Planning application reference AW/353/14/PL

With reference to the above planning application, I am placing my formal objections to the proposed development.

project: 11 Marquis Way - Aldwick			
drawing title: Proposed Site Plan			
drawing status: Planning Application			
date: 09 - 12 - 2014	scale at relevant drawing size 1 : 50 (A1) or 1 : 100 (A3)	no: JW131105 - PL10	rev.: -

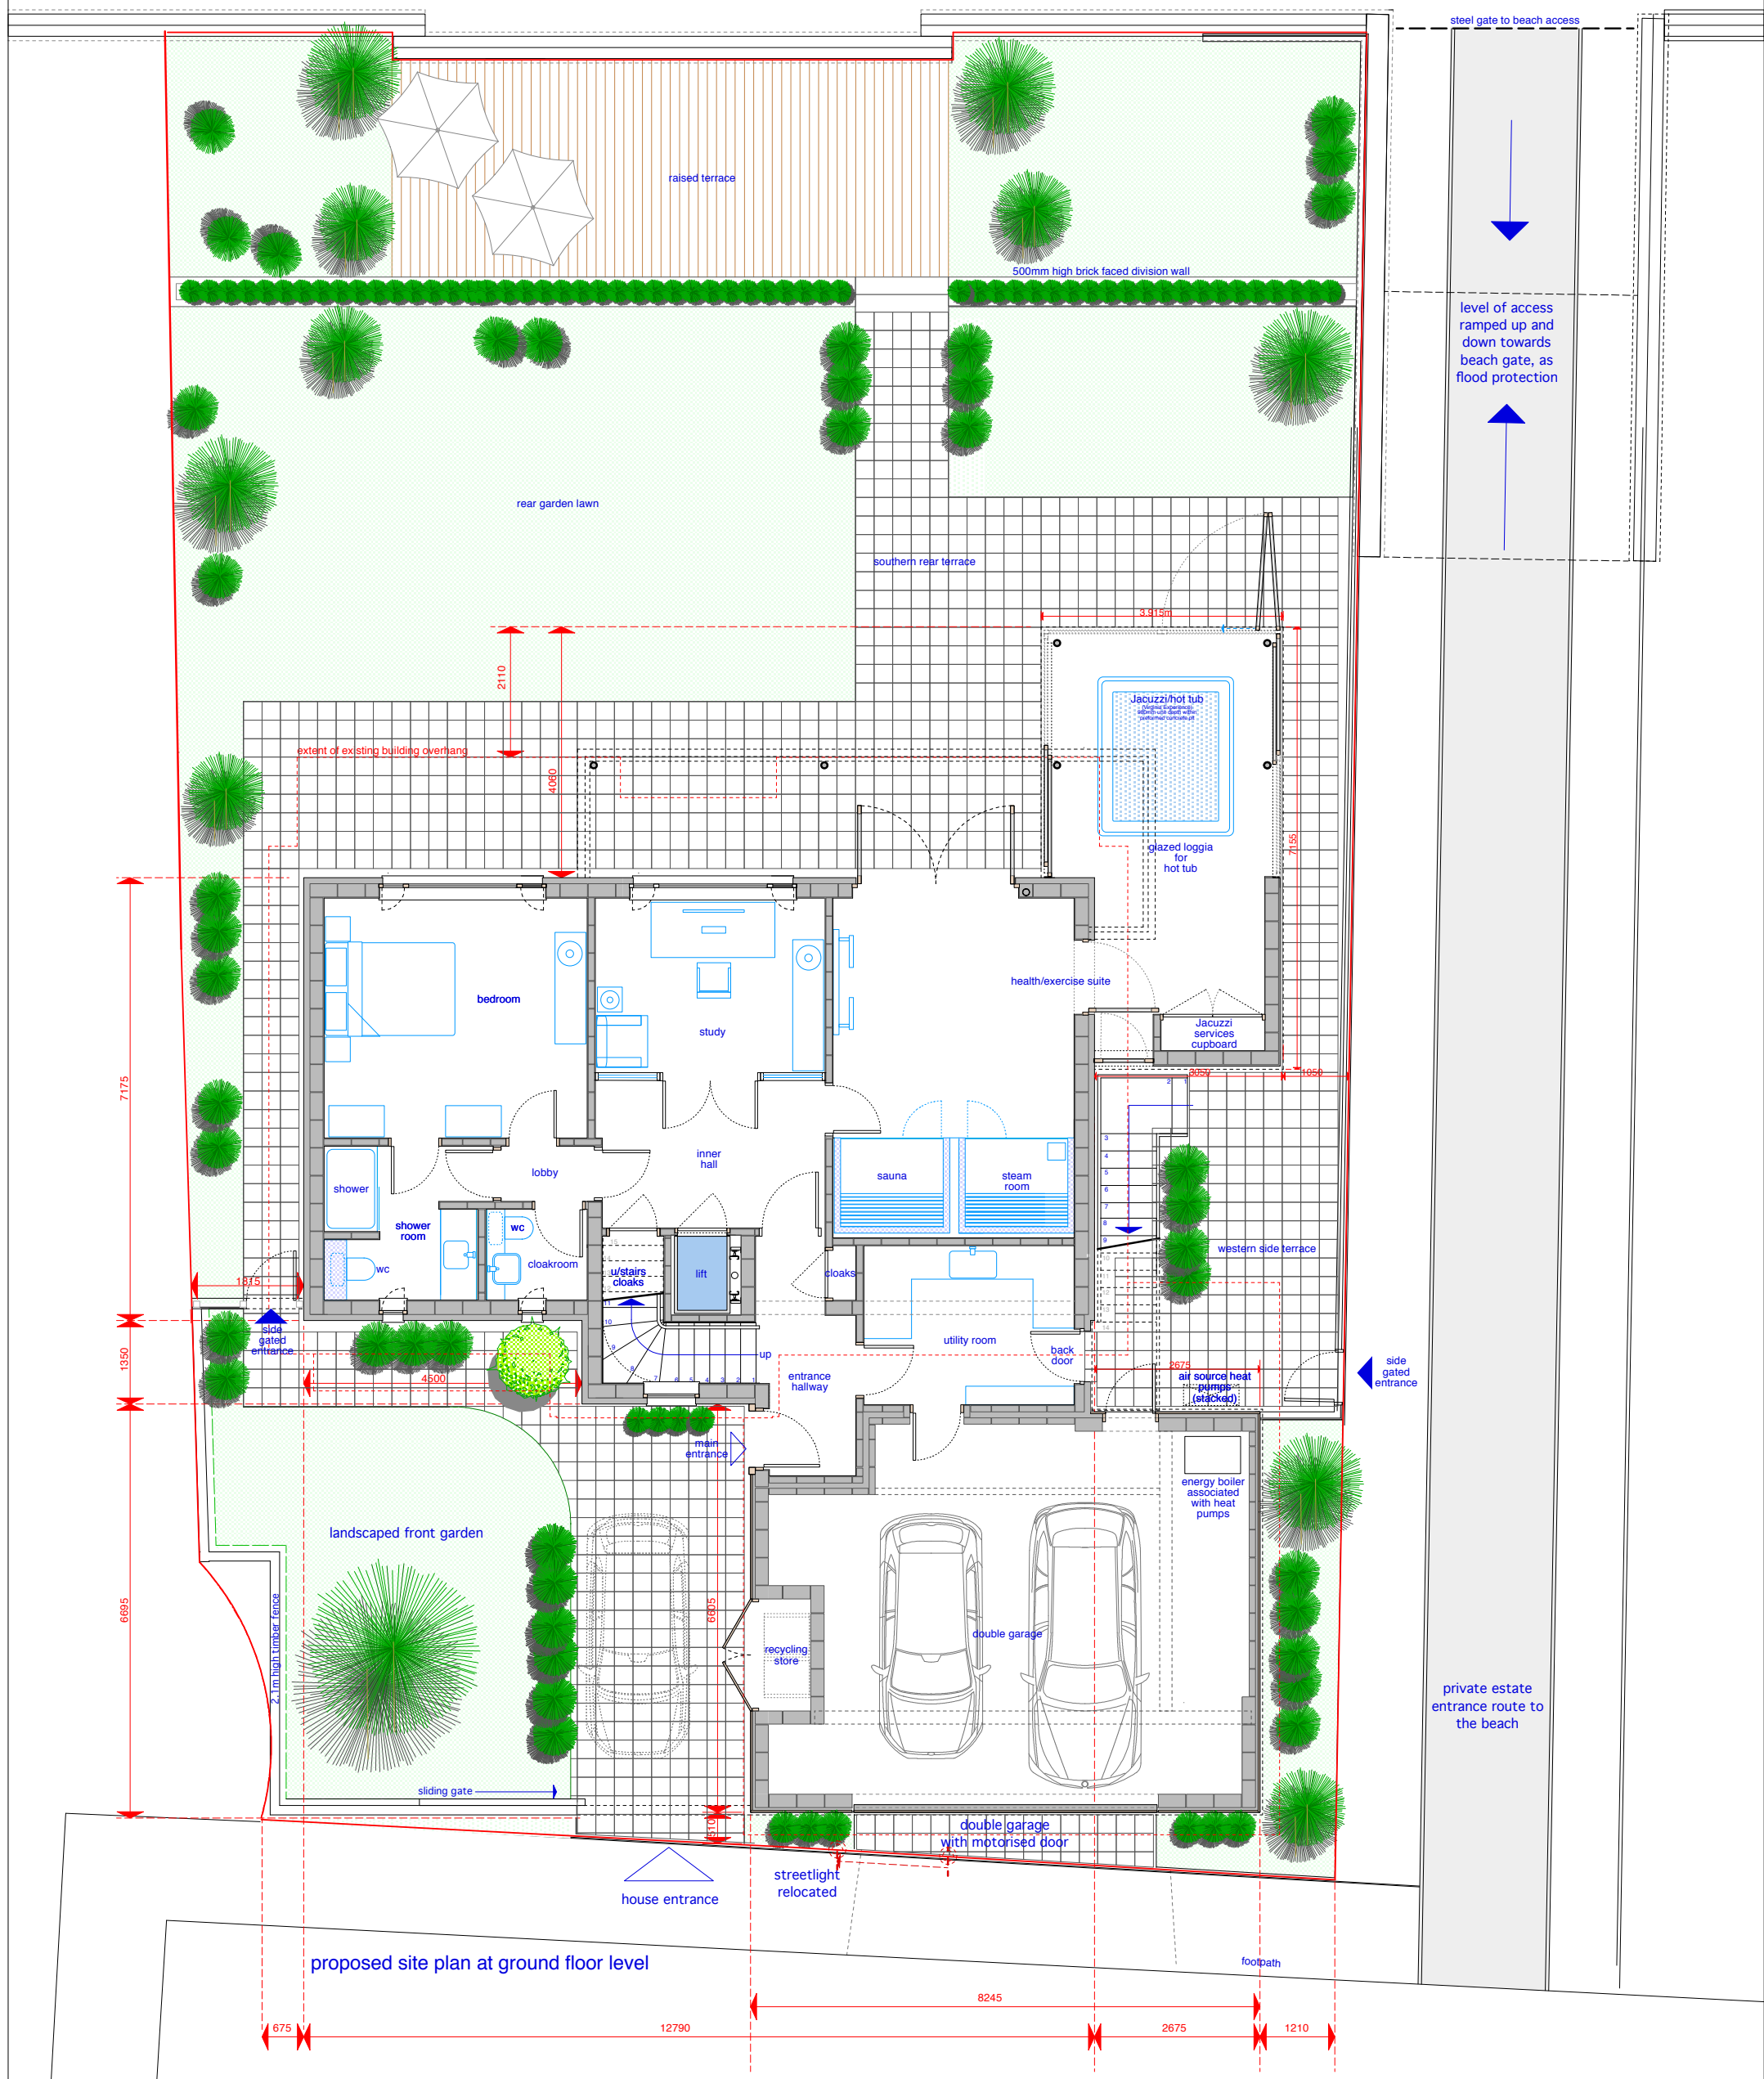
- 1 The design of the proposed house is completely different to any other house on the Pavilions Estate, making use of white rendered block work instead of bricks and having a flat roof instead of a hipped slate roof. Its appearance will clash with nearby houses.

project:	11 Marquis Way - Aldwick		
drawing title:	Existing and Proposed Parking Plans		
drawing status:	Planning Application		
date:	09 - 12 - 2014	scale at relevant drawing size	1 : 100 (A1) or 1 : 200 (A3)
no:	JW131105 - PL16	rev:	-

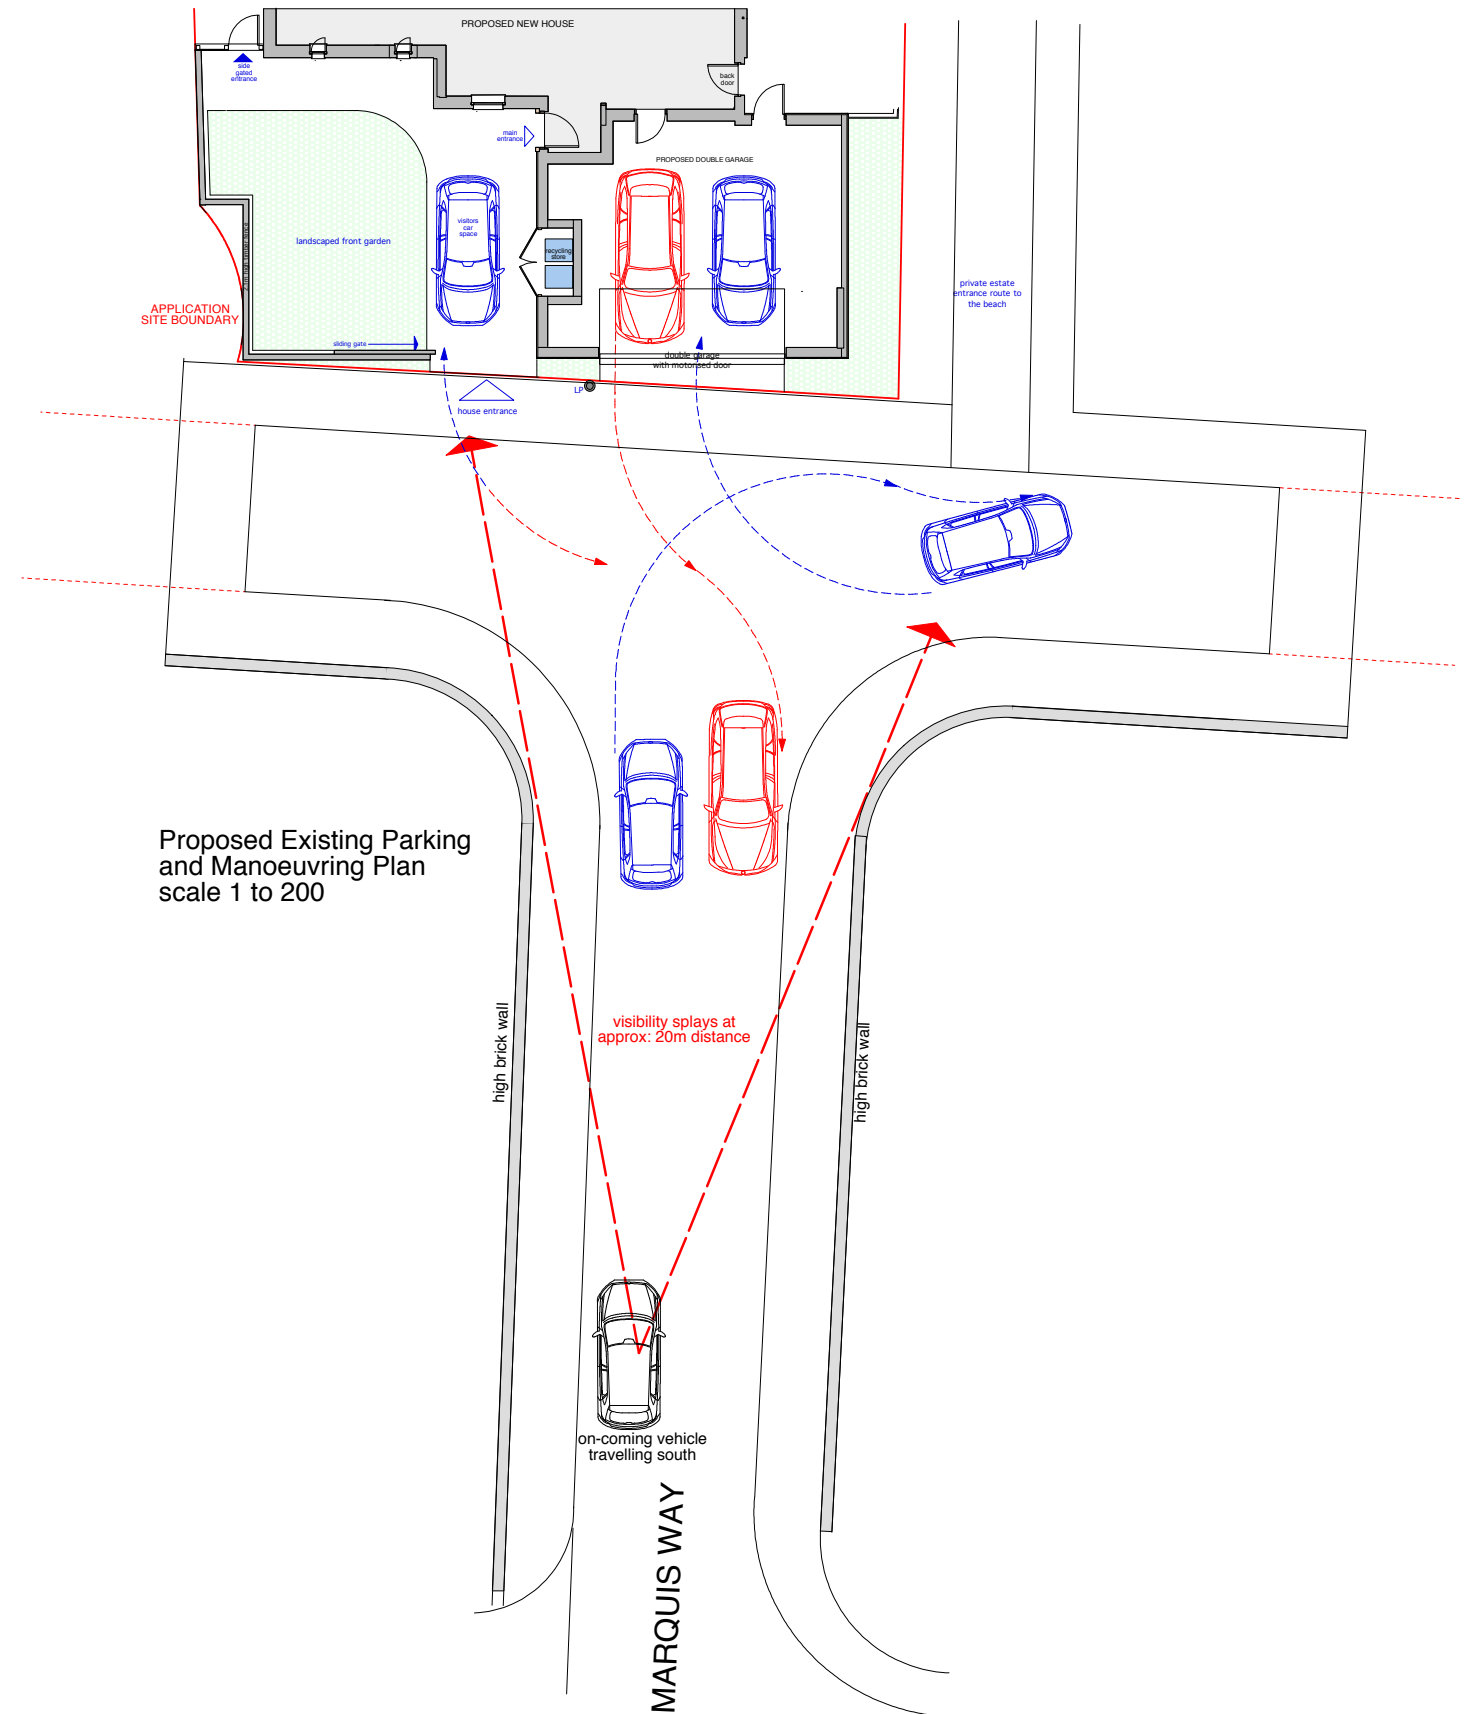
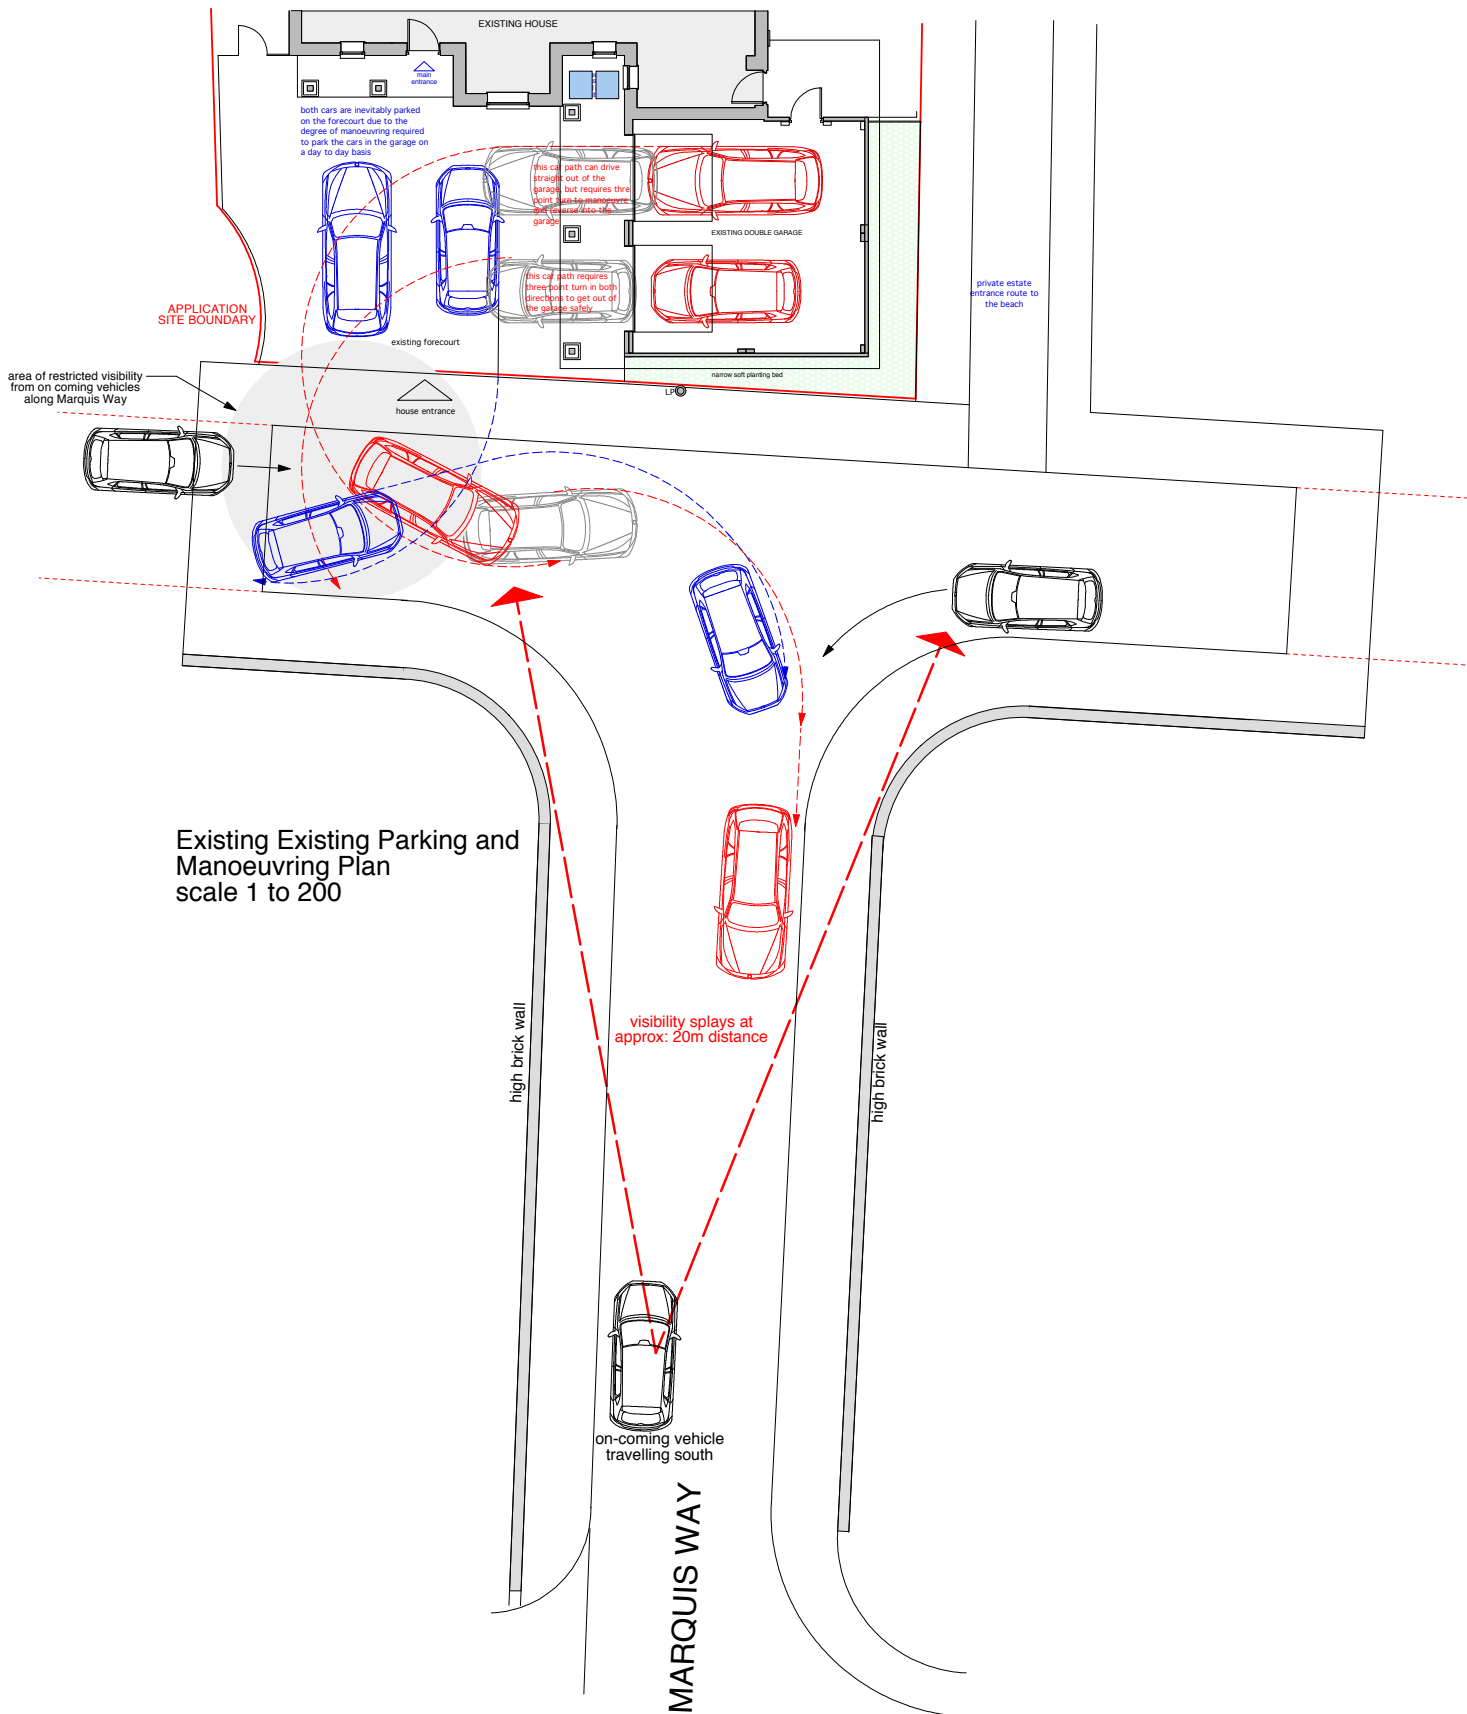
- 5 The proposed change of position of the garage door from the forecourt side to the front of the property will increase the risk of accidents to pedestrians on Marquis Way, as many people walk past the house on their way to the beach gate, and children frequently play in the safe environment there.

project:	11 Marquis Way - Aldwick		
drawing title:	Proposed Sections A and B		
drawing status:	Planning Application		
date:	scale at relevant drawing size	no:	rev:
09 - 12 - 2014	1 : 50 (A1) or 1 : 100 (A3)	JW131105 - PL19	-

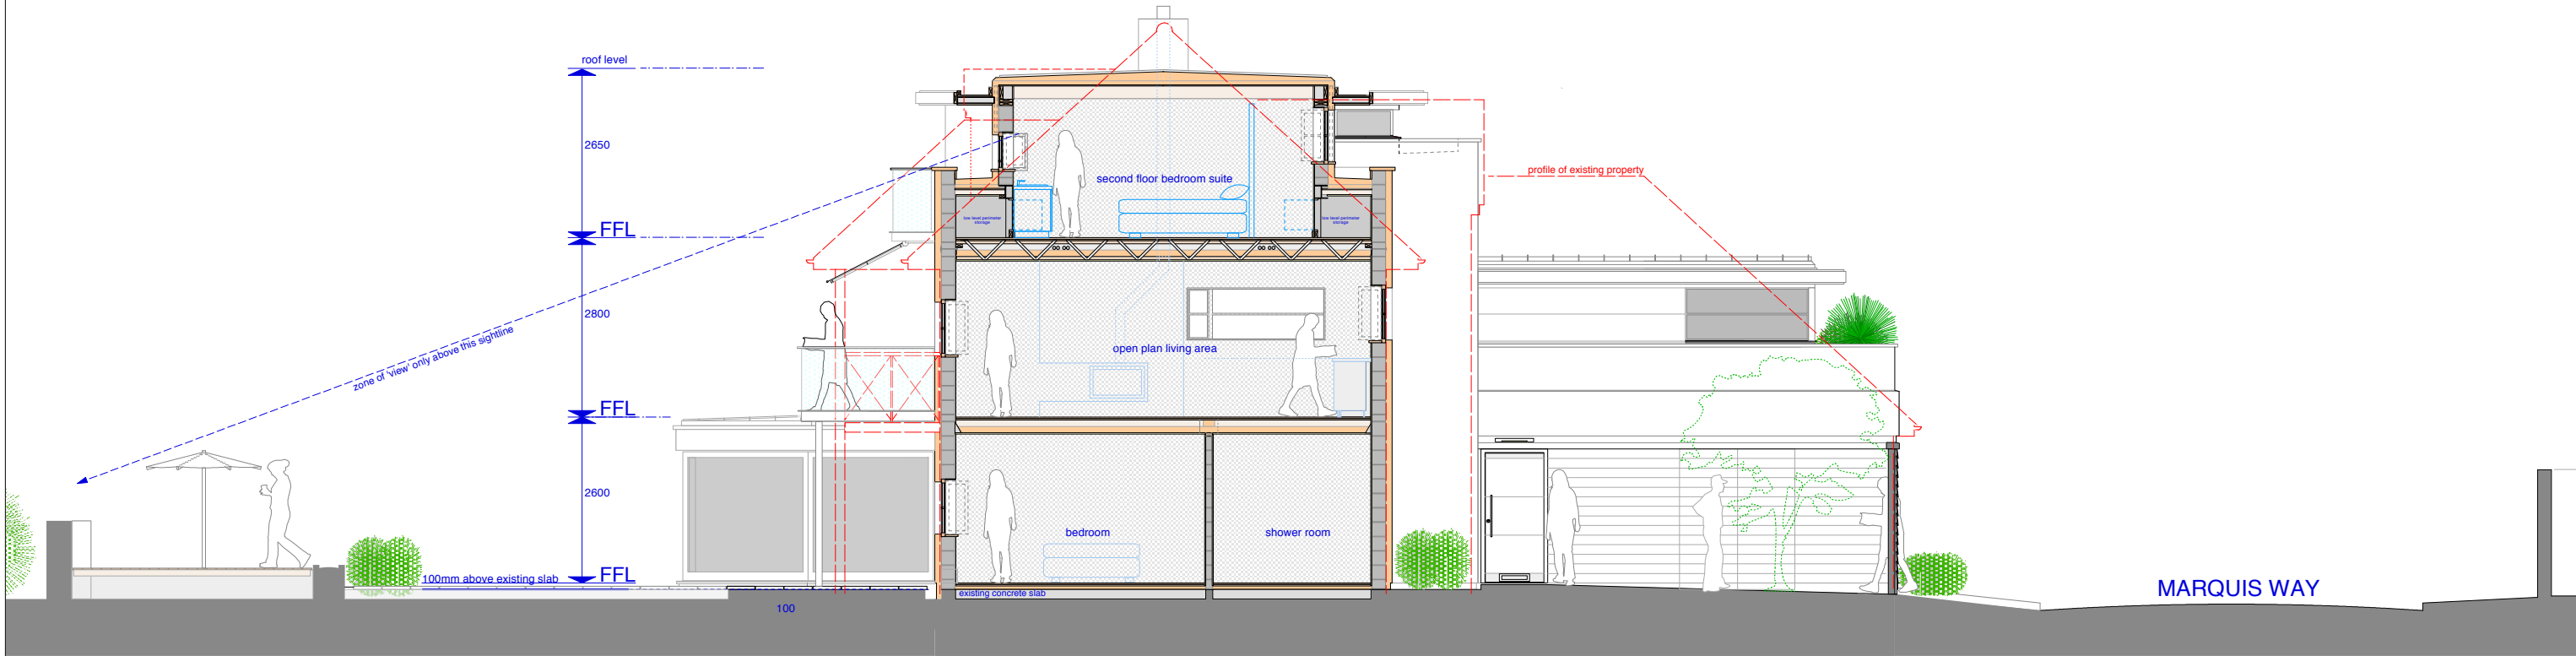
- 4 Due to the changed design of the proposed house, the level of privacy on our house (16) will be seriously diminished, and we will be increasingly overlooked, since the design will bring number 11's living room windows 13 metres nearer to us, looking straight into our garden, first floor bedrooms, and ground floor rooms. Please see the attached photograph.

The proposed balcony would be located immediately above the front of the existing garage wall.
